11 April 2019

RJC:KV15-166

**Re: State Significant Development Application: SSD 7693
InterContinental Hotel and Transport House
Response to request for additional information**

WINTER SOLSTICE - 3:20PM

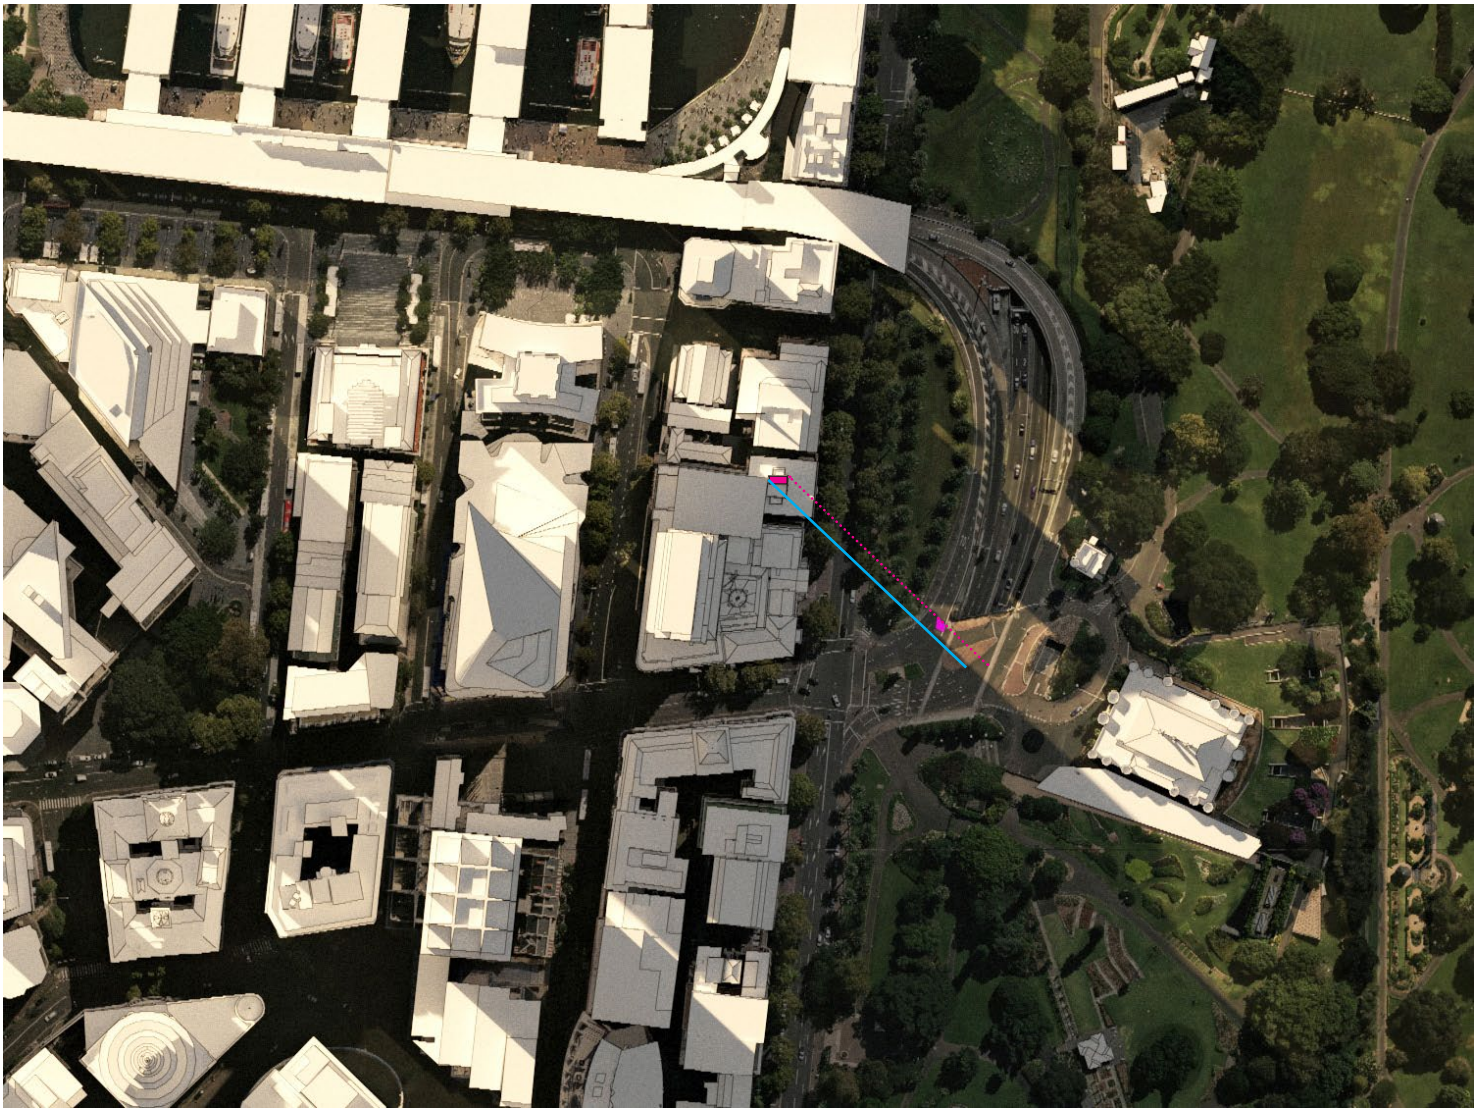
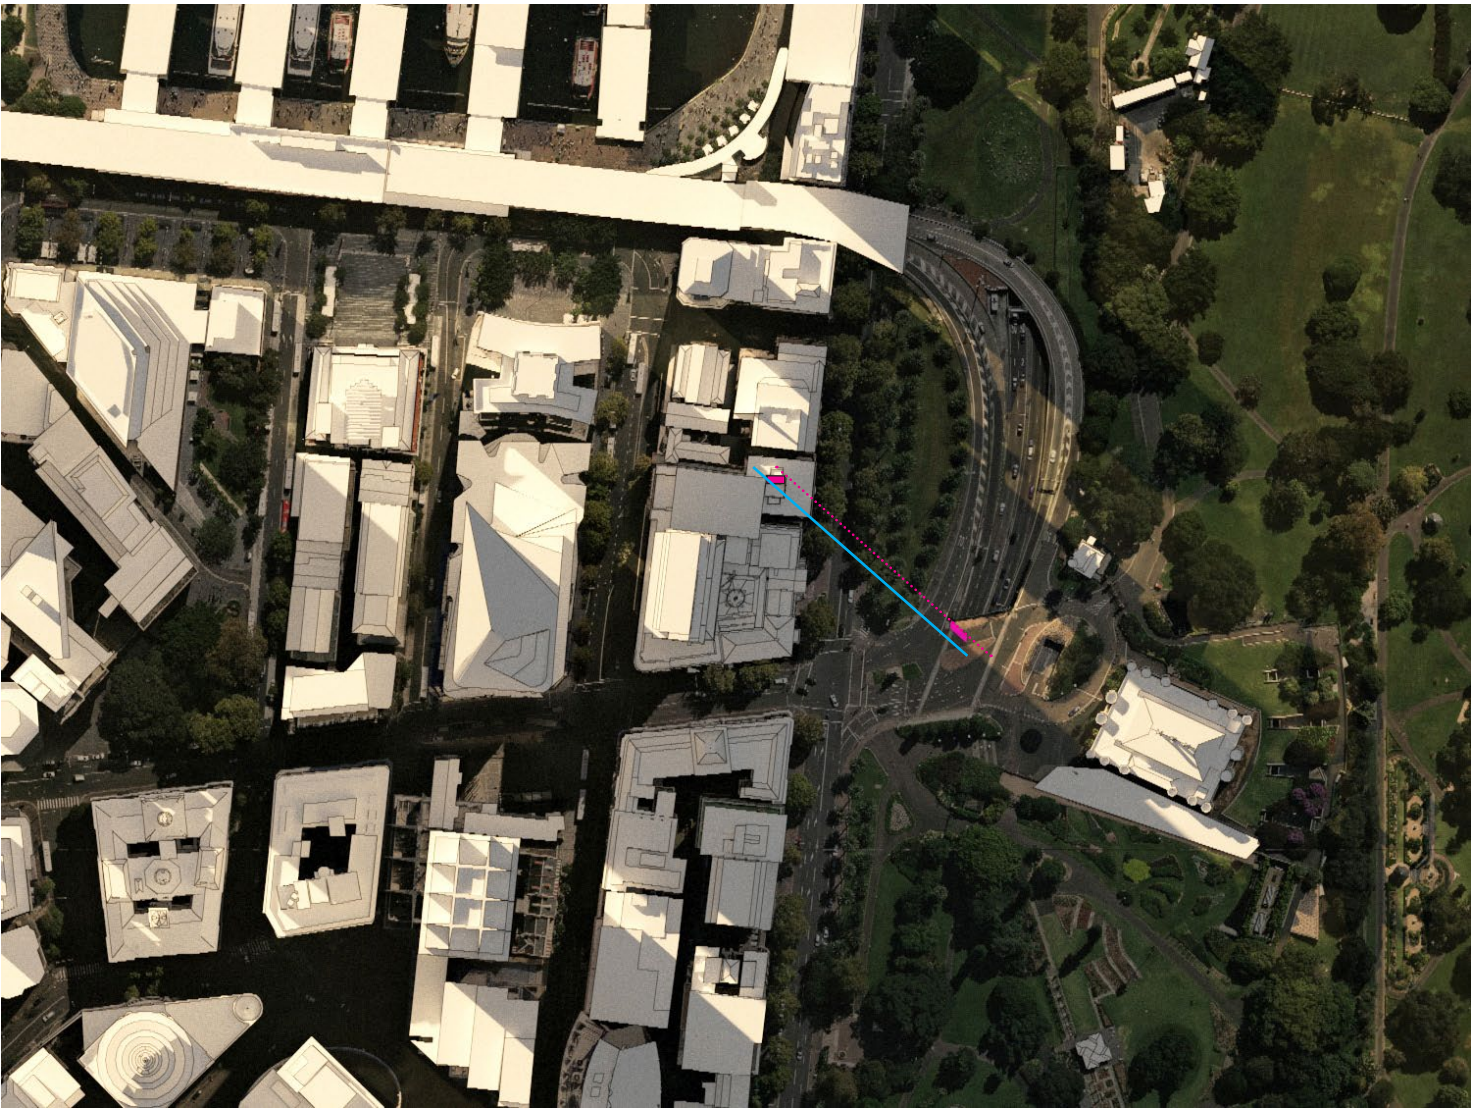
- (b) Shadow diagrams are to be provided in hourly intervals from 9am to 4pm for the winter solstice. In addition, shadow diagrams for half hour intervals are to be provided from 2pm-4pm on winter solstice in order to clearly understand the overshadowing impact to the Royal Botanic Gardens. The extent (i.e. duration and area in m²) of overshadowing to the Royal Botanic Gardens (RBG) shall also be quantified.**

- (c) Clarify how the increase in overshadowing at 3pm (as shown on Drawing No. ST1-DA_808) is attributed solely to the extension of the building envelope over the Transport House lift motor room (described in Section 4.3 of your letter dated 1 March 2019, as replicated below) and not as a result of the overall building envelope over the Transport House.**

In order to further analyse this impact, shadow diagrams have been produced for 10 minute intervals from 2.30pm to 4pm, principally to identify the area of overshadowing as requested by the Department. Drawings titled Solar Analysis – RBG Shadows 2-5 show the location and area extent in square metres of overshadowing for each 10 minute interval. The shadow impact from the emergency egress extension on Transport House is shown in table form overleaf:-

Time	Area of Shadow (m ²)	Location
2.30pm	0m ²	Nil
2.40pm	11m ²	Royal Botanic Gardens
2.50pm	20m ²	Royal Botanic Gardens
3.00pm	12m ²	Royal Botanic Gardens
3.10pm	18m ²	Footpath and road
3.20pm	15m ²	Footpath and road
3.30pm	25m ²	Footpath and road
4.00pm	0m ²	Nil

In summary, this shows that egress extension on Transport House casts a small shadow over The Royal Botanic Gardens site for approximately 30 minutes in mid-winter. The extent of this shadow reaches a maximum area of 20m² at 2.50pm.
